National Highways Planning Response (NHPR 21-09) Formal Recommendation to an Application for Planning Permission

Council's Reference: 21/03268/OUT

Location: OS Parcel 2636, NW of Baynards House, Ardley

National Highways Ref: 92859

Section 6-6 (1:250 @A1)

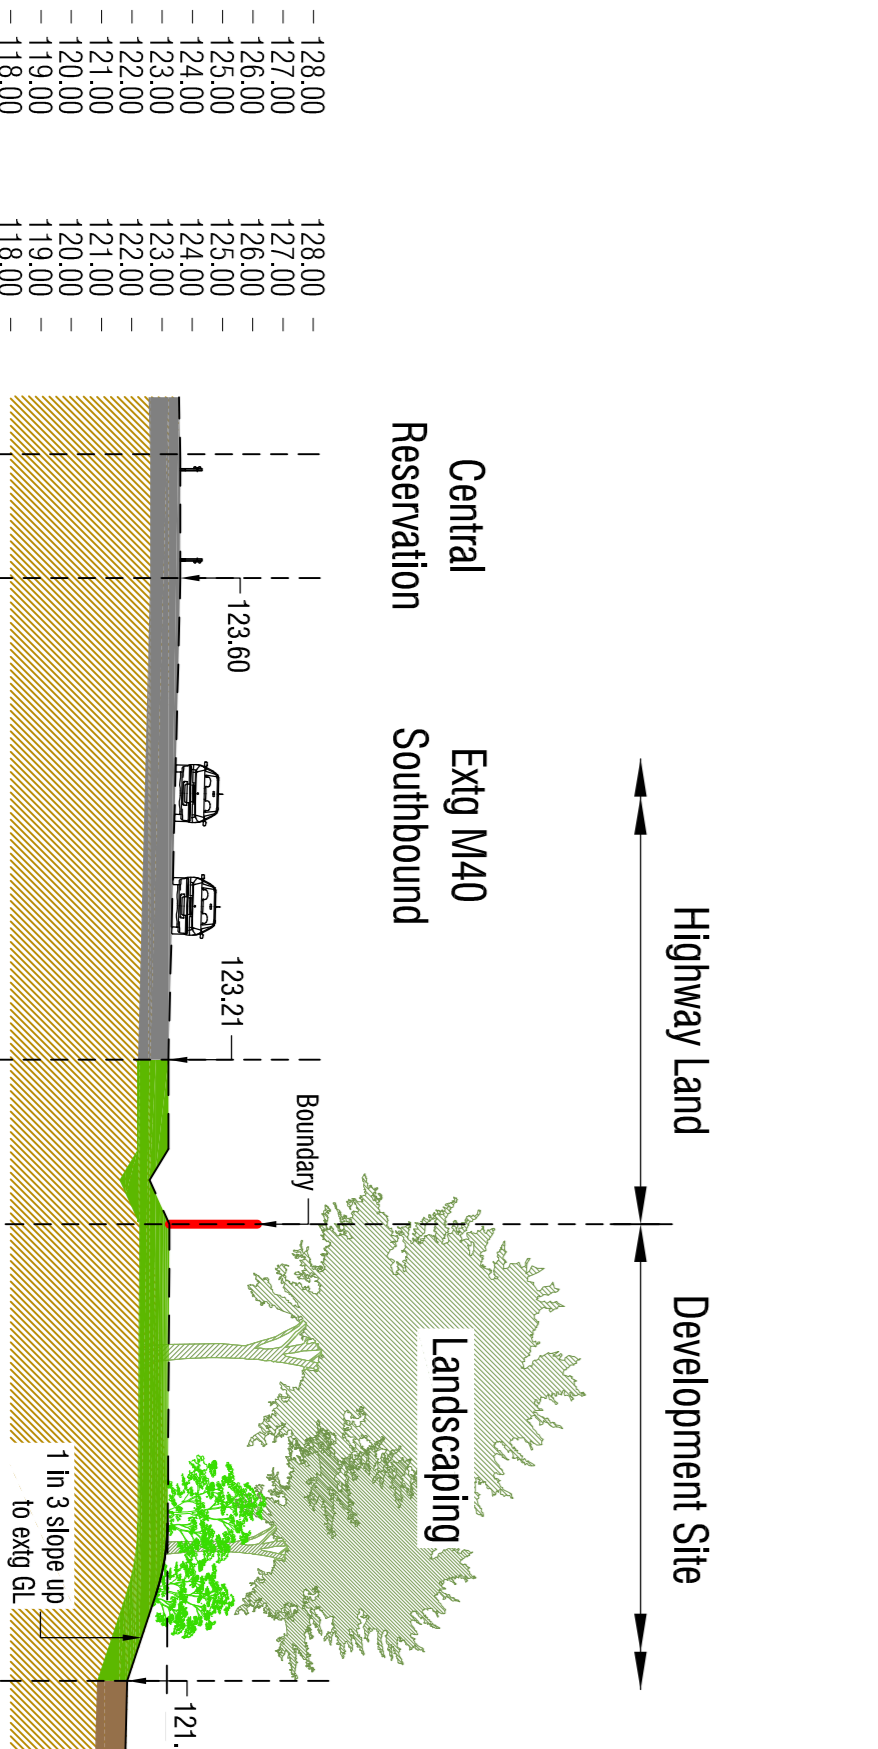
The applicant will need to advise / confirm if there will be any earthworks associated with the development(s) in relatively close proximity to National Highways boundaries (e.g. the stability of the balancing ponds, etc). In the first instance, some cross sections (to scale) through the boundaries showing the proposed extent of the development, its features and any proposed changes in elevation (excavations, landscaping) etc should be submitted for further assessment. Once received, we will review to determine the possible extent of any geotechnical reporting under the Design Manual for Roads and Bridges (DMRB) standard CD 622, which may be required to confirm the extent of any geotechnical risk to the SRN.
